Consultation Response from: Planning Policy Group		
Address: Land adjacent 67 Chapelgate Scholes Holmfirth		
Proposal: 2022/92406 Erection of 10 affordable dwellings and associated works including resident play zone.		
Date Responded: 30/11/2022	Responding Officer: Steven Wright	Responding Ref:
The Local Plan was adopted on 27th February 2019. The Holme Valley Neighbourhood Development Plan (HVNDP) was made in December 2021 and forms part of the Development Plan for Kirklees. The following response relates to specific policies which are particularly relevant to the proposal. The Development Plan should be considered as a whole, so other policies not mentioned here may also apply. The site lies within the Green Belt as designated on the Kirklees Local Plan. NPPF paragraph 149 states that a local planning authority should regard the construction of new buildings as inappropriate in the Green Belt unless the building falls within one of the exceptions listed in the paragraph, the relevant one in this case being criterion f) which allows for limited affordable housing for local community needs under policies set out in the development plan, including policies for rural exception sites.

Tensile Canopy Plan:
Tensile Fabric Structures - Single Azure

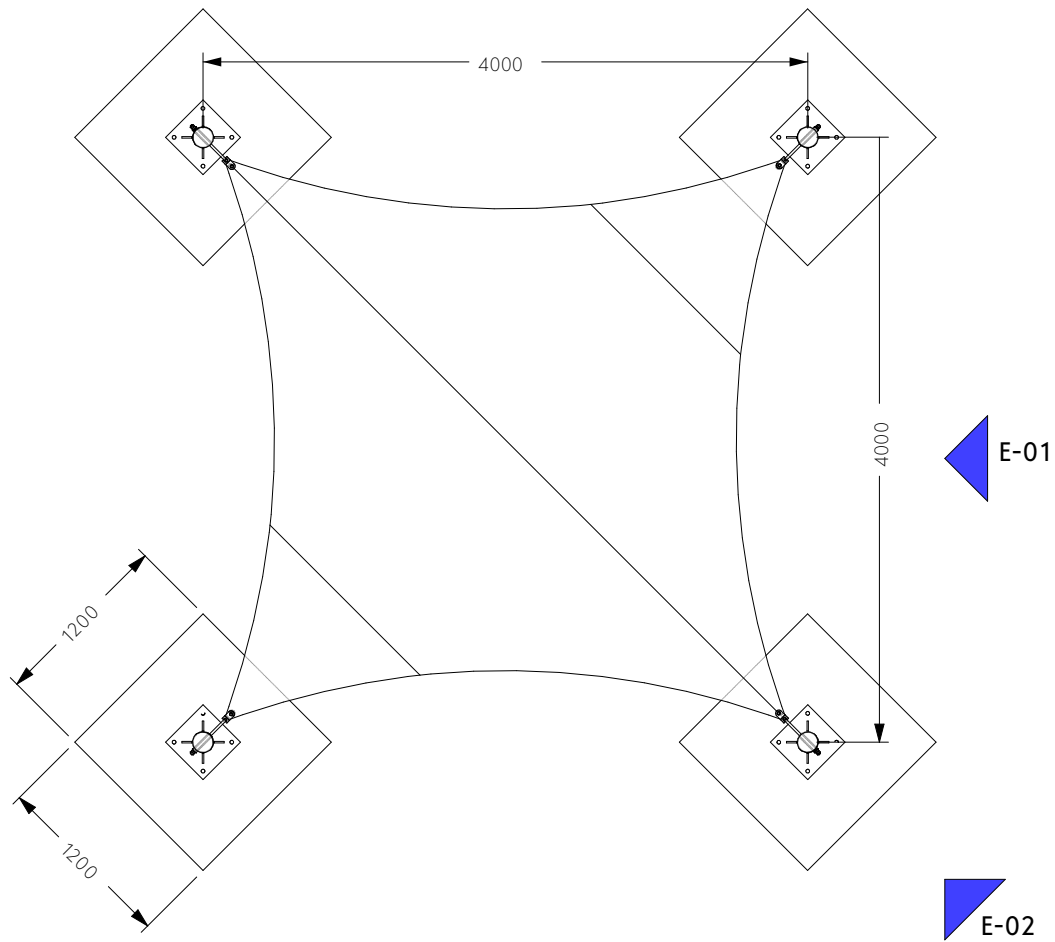
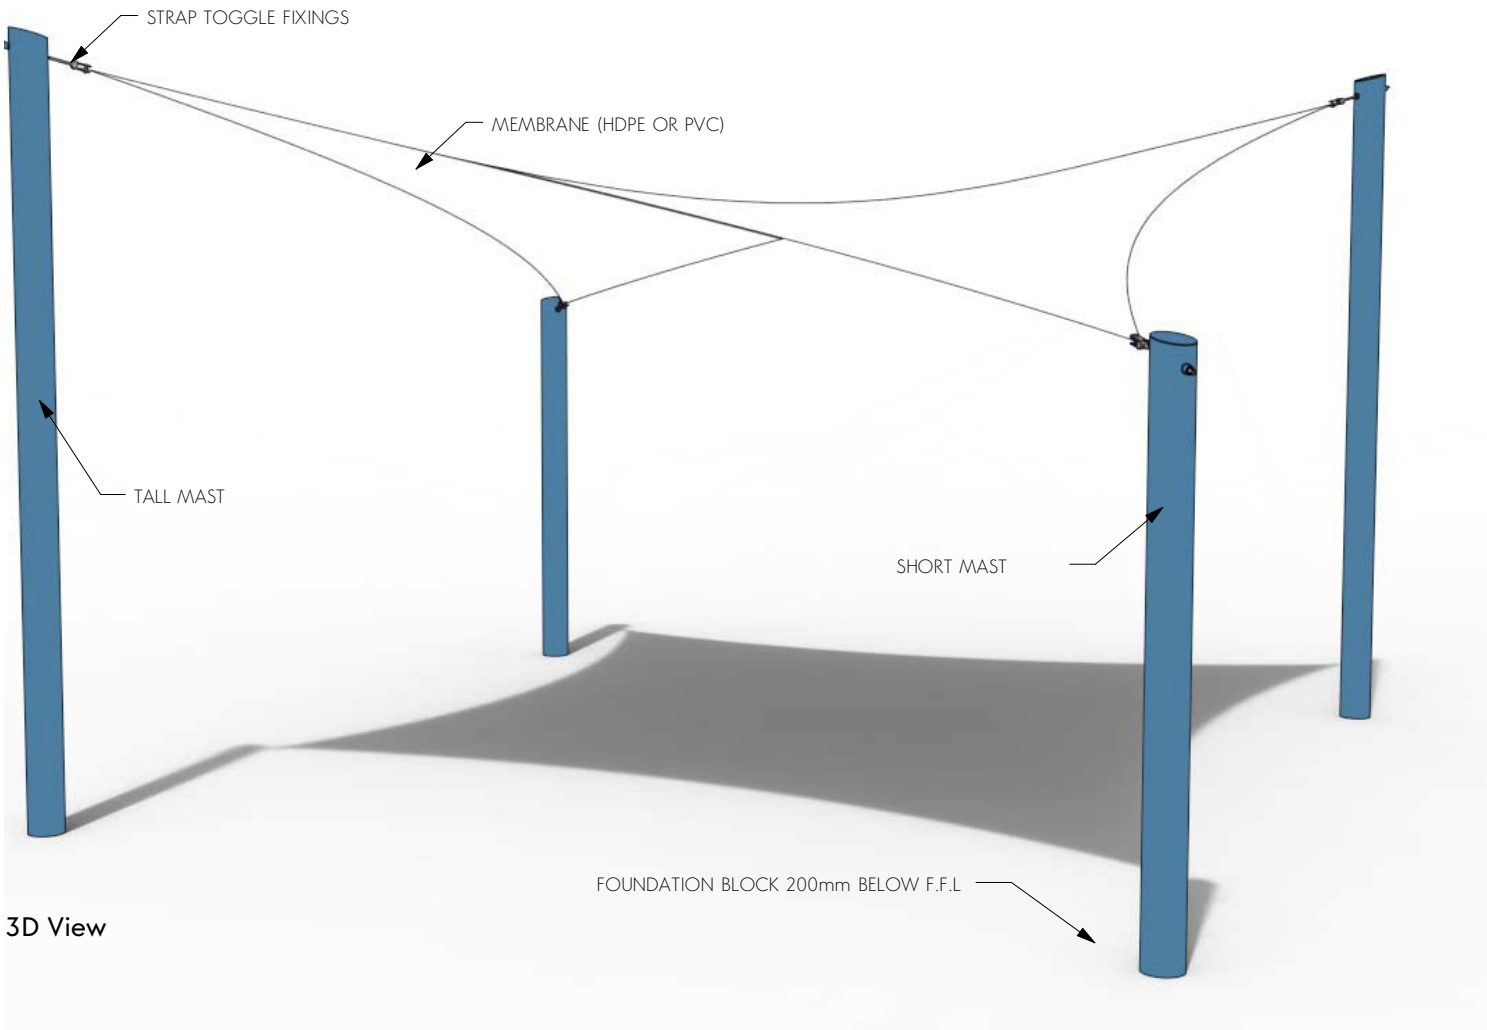
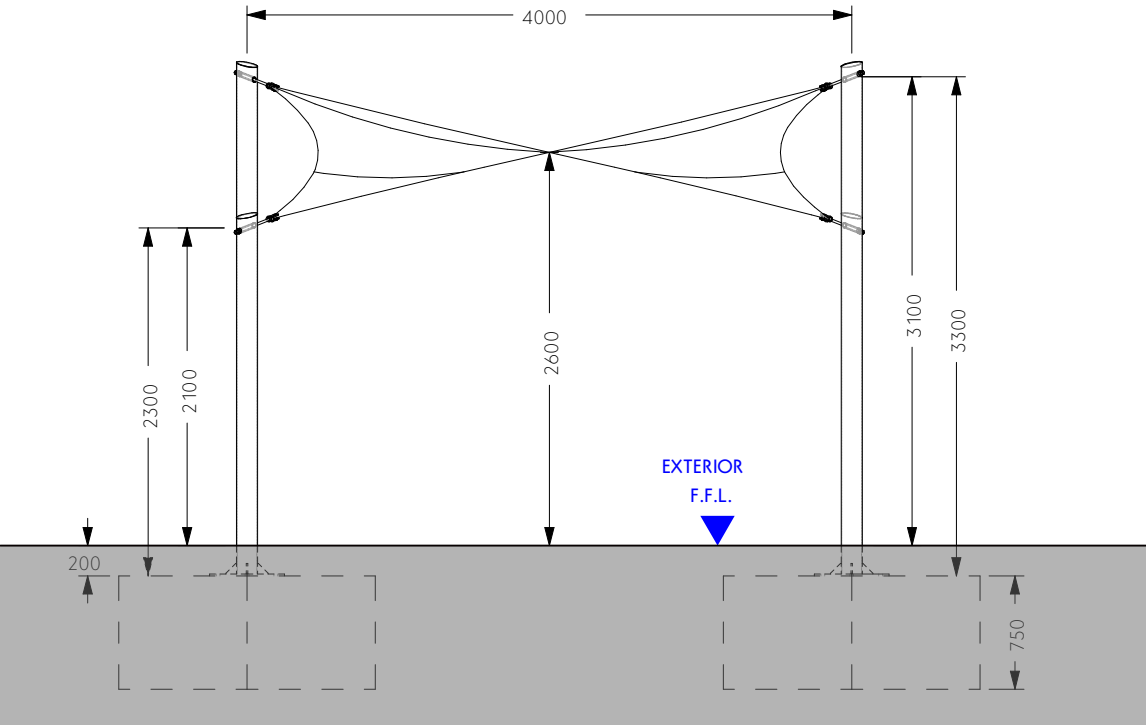
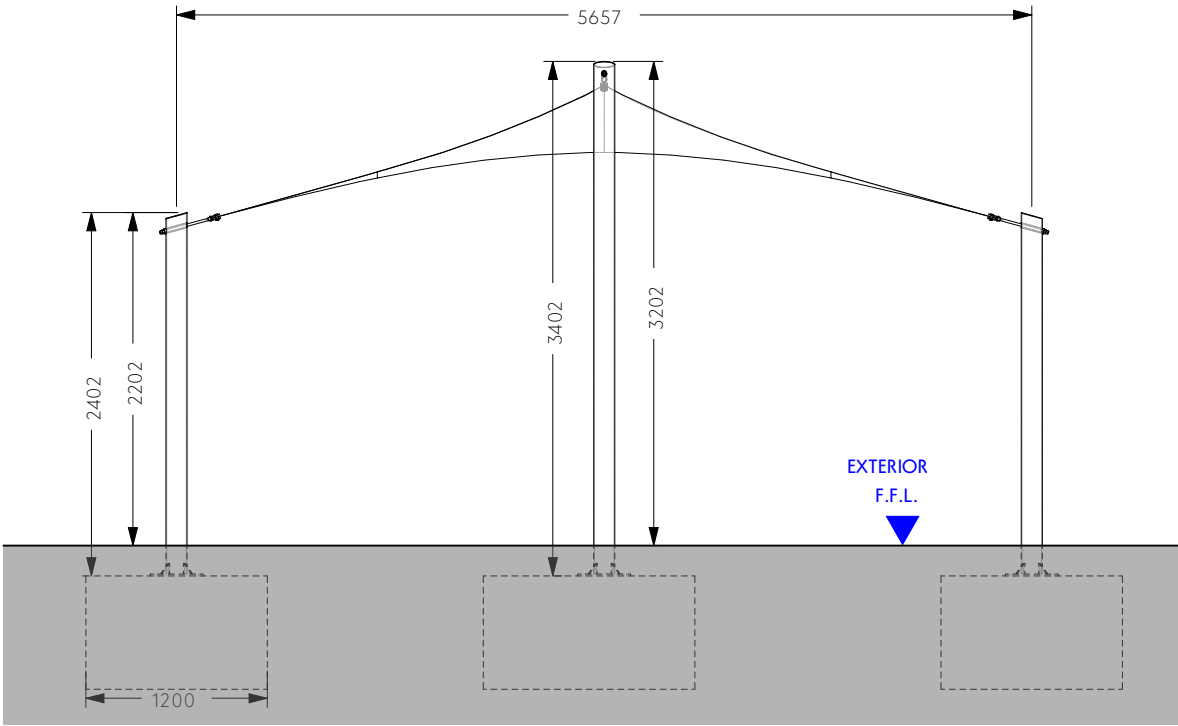
This scheme must be considered as a whole. The current proposed layout including the communal areas and structures, particularly the communal canopy structure, the vertical retaining walls (including to the west that would form the backdrop to the site), appear to create an overly urbanised character to this proposed development. The development should focus on the essential elements to deliver a high-quality affordable housing proposal whilst limiting the impact on the green belt through minimising the non-essential components of the scheme.

Bin Store - Plan and Elevations

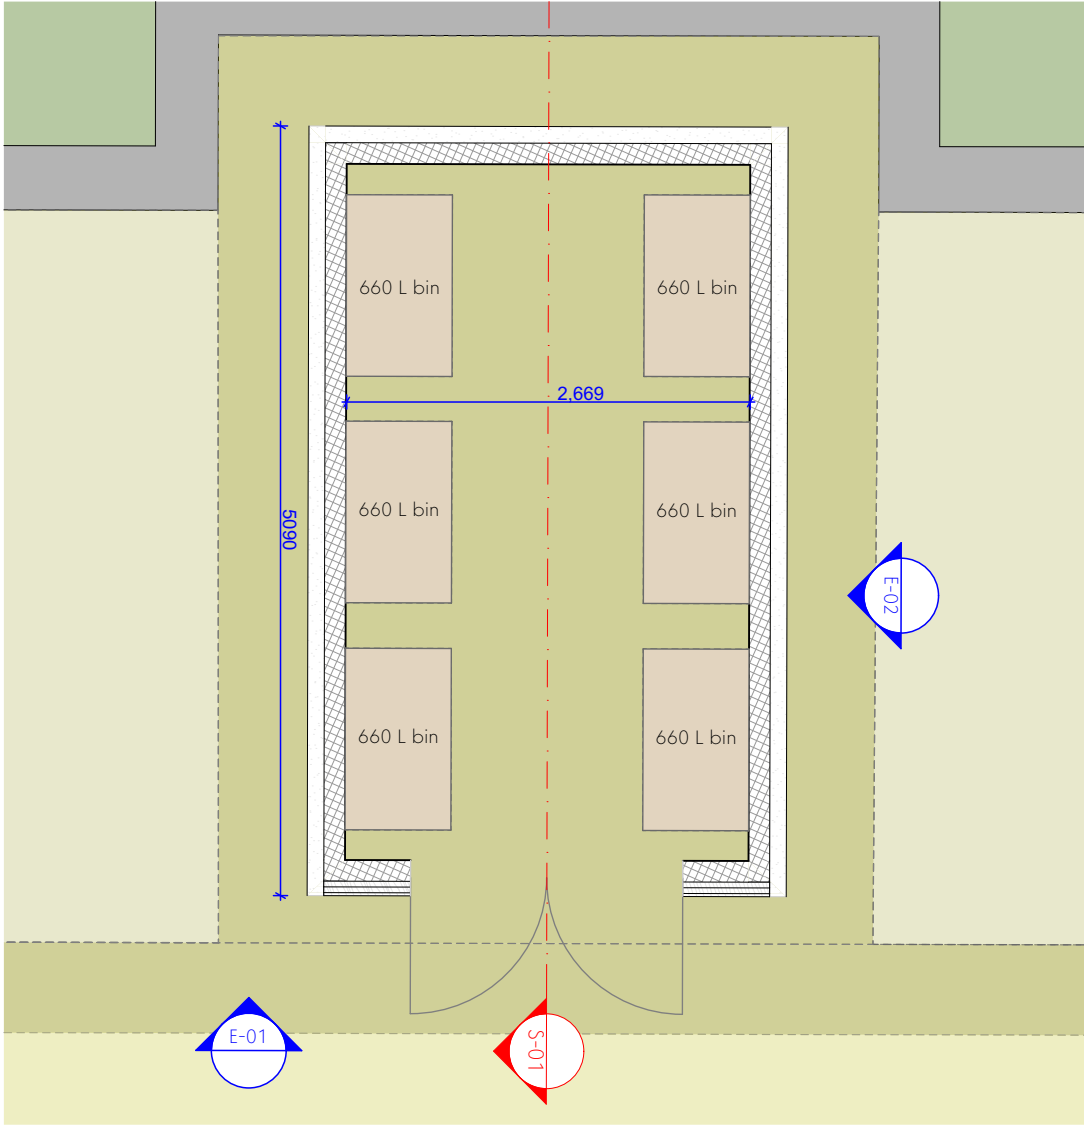
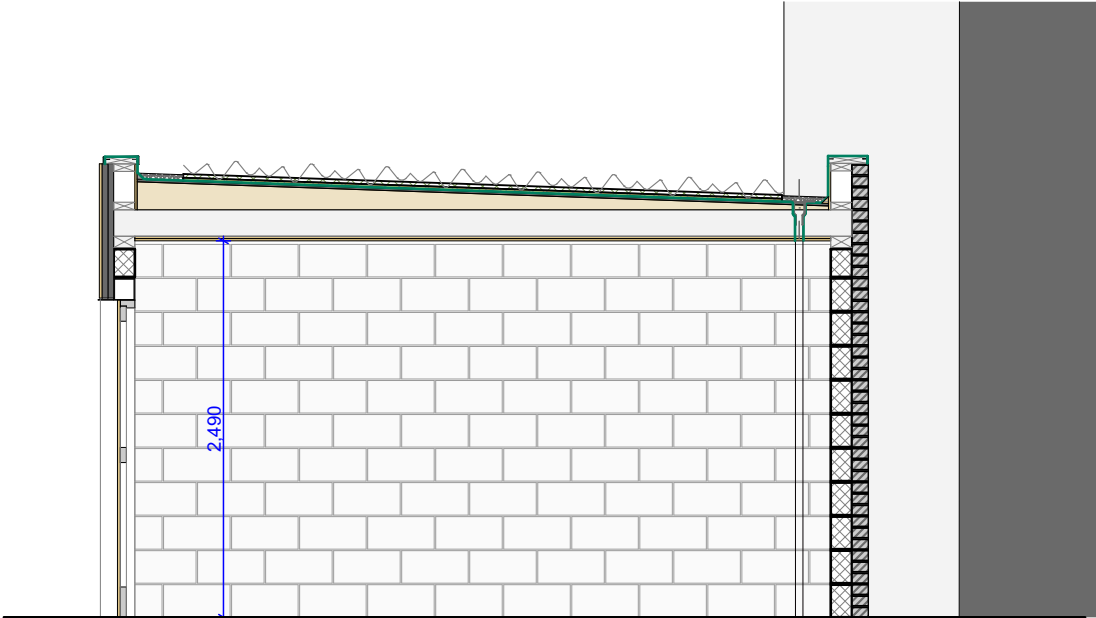
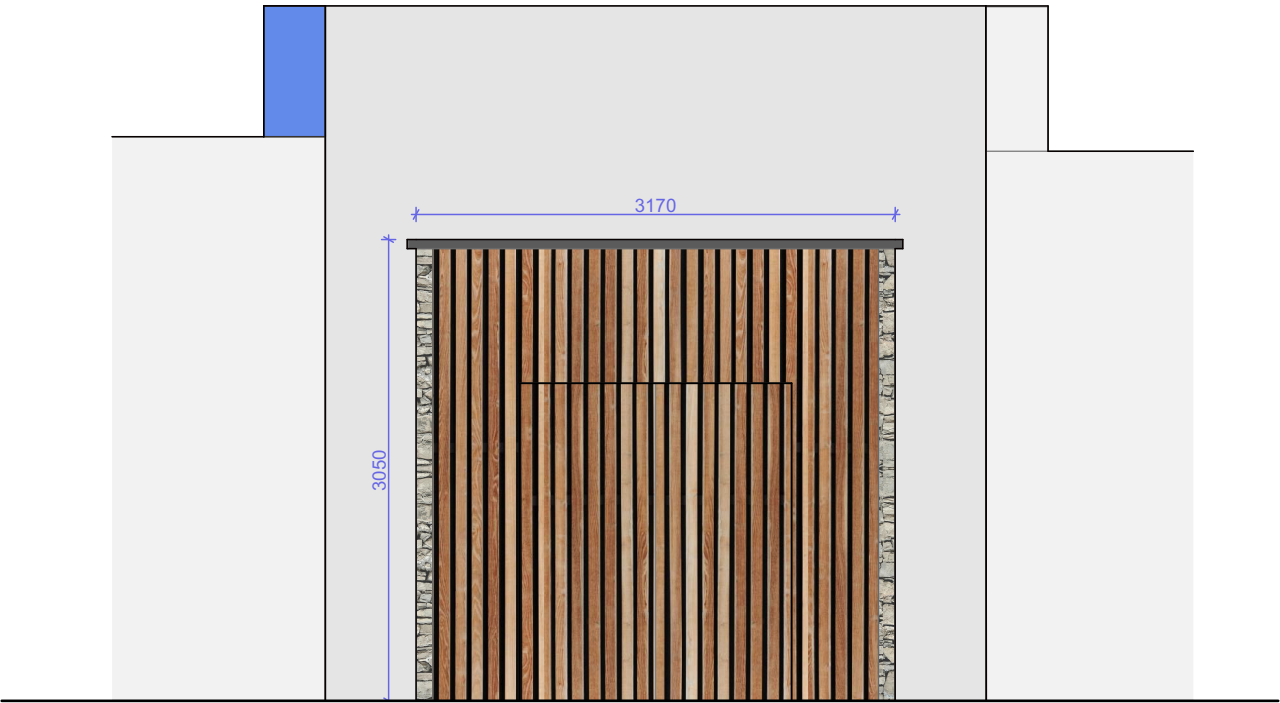
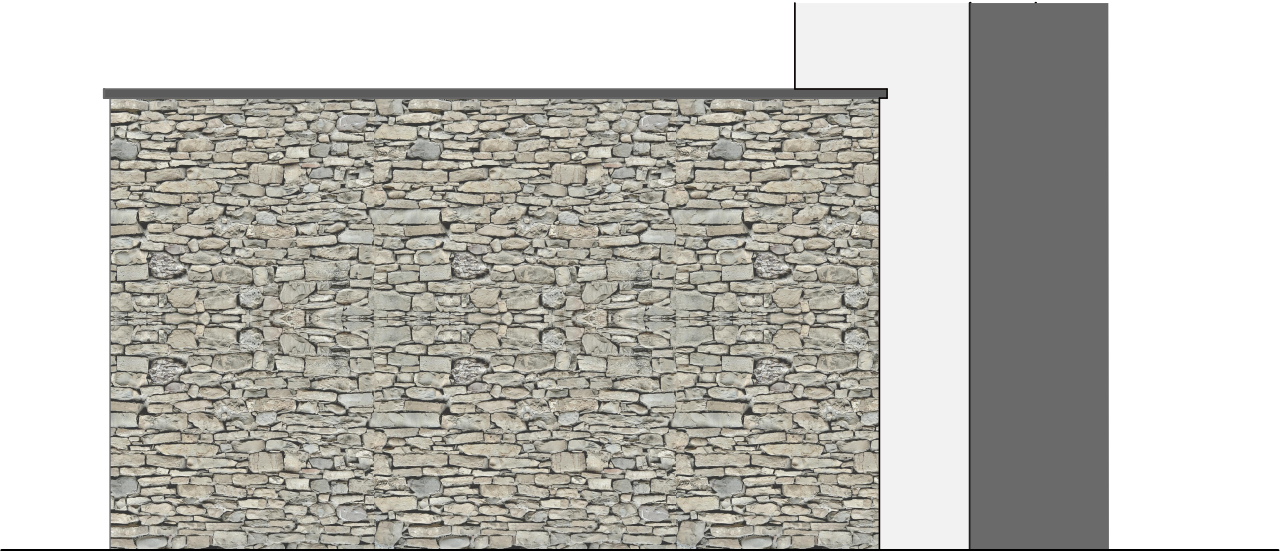
If the principle of housing is accepted there are elements of this proposal, such as a bin store, which are expected to be provided on site to enable the effective operation and delivery of a high-quality affordable housing scheme. For the non-essential aspects of this scheme, their inclusion needs to be justified and impacts on openness considered. Consideration should be given to all aspects of the proposal to ensure that the design is in keeping with the green belt location of this site.

Proposed Site Sections

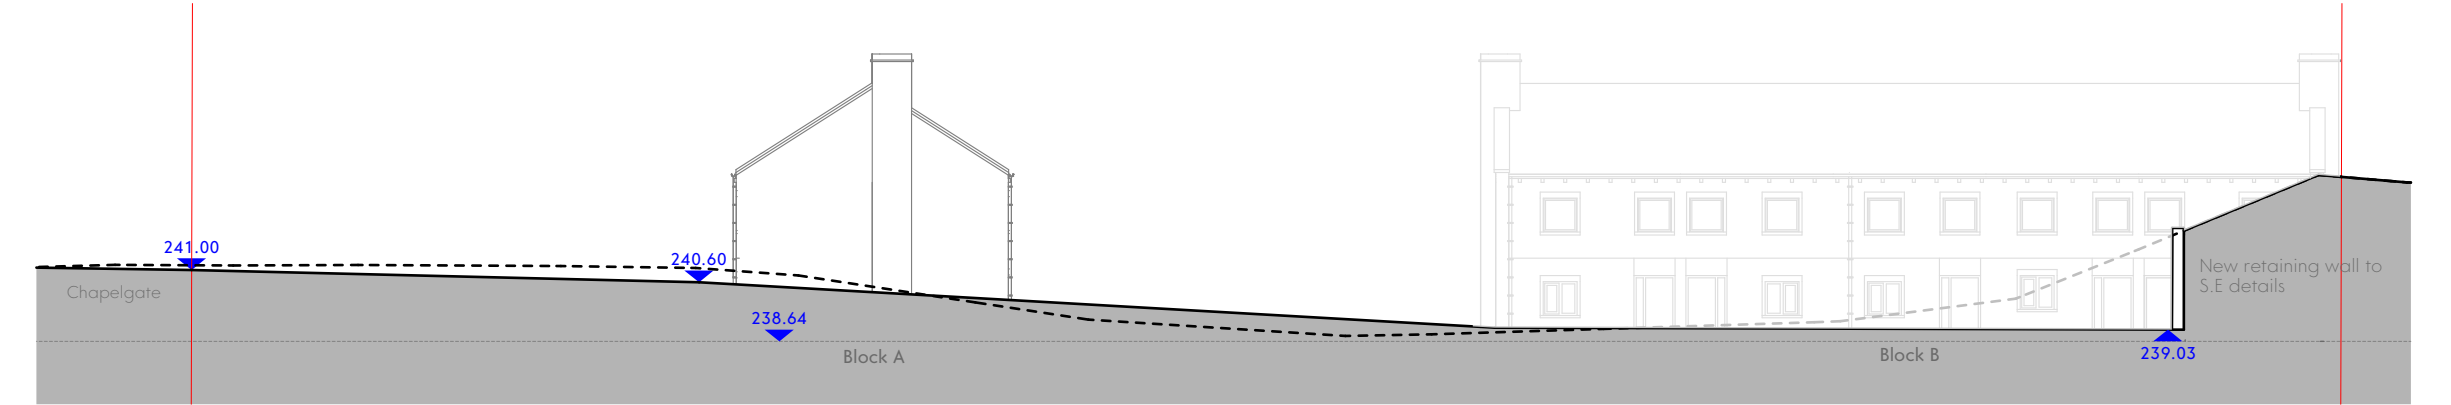
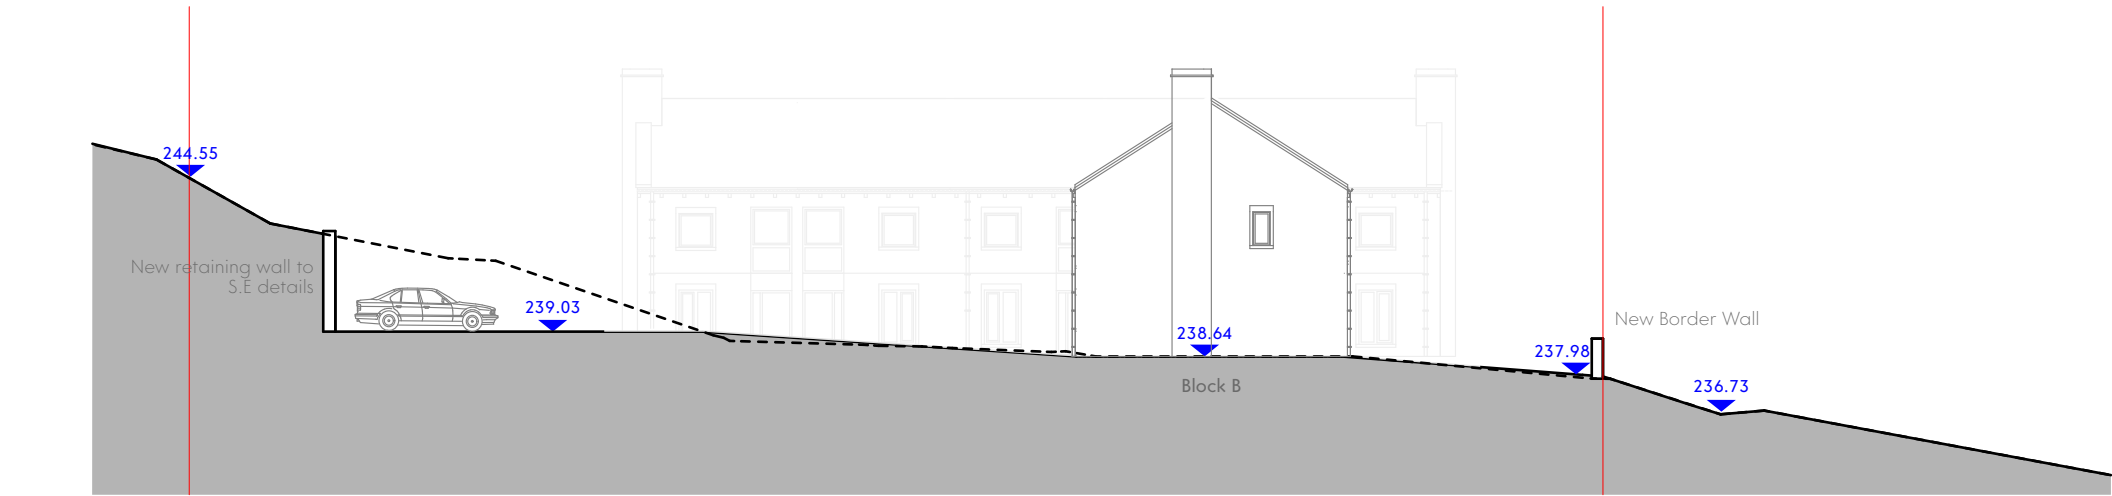
To facilitate the level ground required for the row of car parking spaces at the western edge of the site, an engineering operation to create a vertical retaining wall is proposed to allow for the significant difference in levels between the site and the field and property no. 67 Chapelgate to the west. There does not appear to be any indication as to the method of construction or landscaping treatment of this retaining structure, or of the other proposed retaining walls. The rest of the scheme has been designed with a series of retaining walls so that the blocks of houses are built on level platforms; for example between Dean Bridge Lane and Block A and between Block A and the raised car parking (section CC Proposed Site Sections). Another significant retaining wall is proposed at the south-east of the site between the site and the fields off Dean Bridge Lane.

Retaining walls can have a significant impact both on the openness of the green belt and the purposes of including land within it, by creating permanent structures to the detriment of openness and which can act as visual barriers, and by the creation of an artificial landform which encroaches on the character of the countryside. It is acknowledged that this site was a quarry where the topography has already been altered, but revegetation and the passage of time has given the site a more natural appearance which would be significantly altered by the proposal as designed. Local Plan policy LP32 requires that proposals should be designed to take account of and seek to enhance the landscape character of the area and the setting of settlements and buildings within the landscape. LP24 states that the form, scale, layout and details of all development respects and enhances the character of the landscape. Careful consideration therefore needs to be given to the design and landscaping treatment of any retaining structure, which ought to be sloped and landscaped banks, not solid retaining walls.
